Department of Industry

OUT18/13113

Mixed use development at 35 Honeysuckle Drive (8999) EIS Exhibition

Figure 3: Steady State Head Distribution (Case A - Piled walls installed into Unit 4 clay)

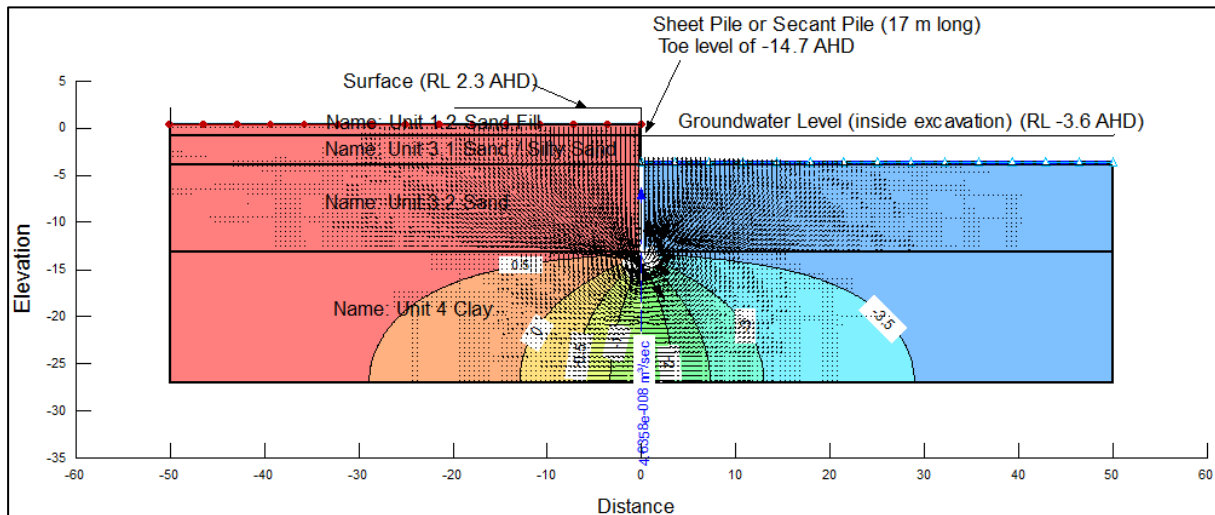
- Appendix AD (Groundwater Inflow Analysis) outlines Case A and B for groundwater rates (page 12). DoI – Water requests the Case B rate is verified to confirm the groundwater take per day equals 12900 to 23100 Kilolitres or Litres.
- Appendix AD (Groundwater Inflow Analysis) outlines a temporary groundwater extraction licence will need to be sought from WaterNSW. The temporary groundwater extraction licence is to be obtained by the Natural Resource Access Regulator (NRAR), within the Department of Industry – Lands and Water.
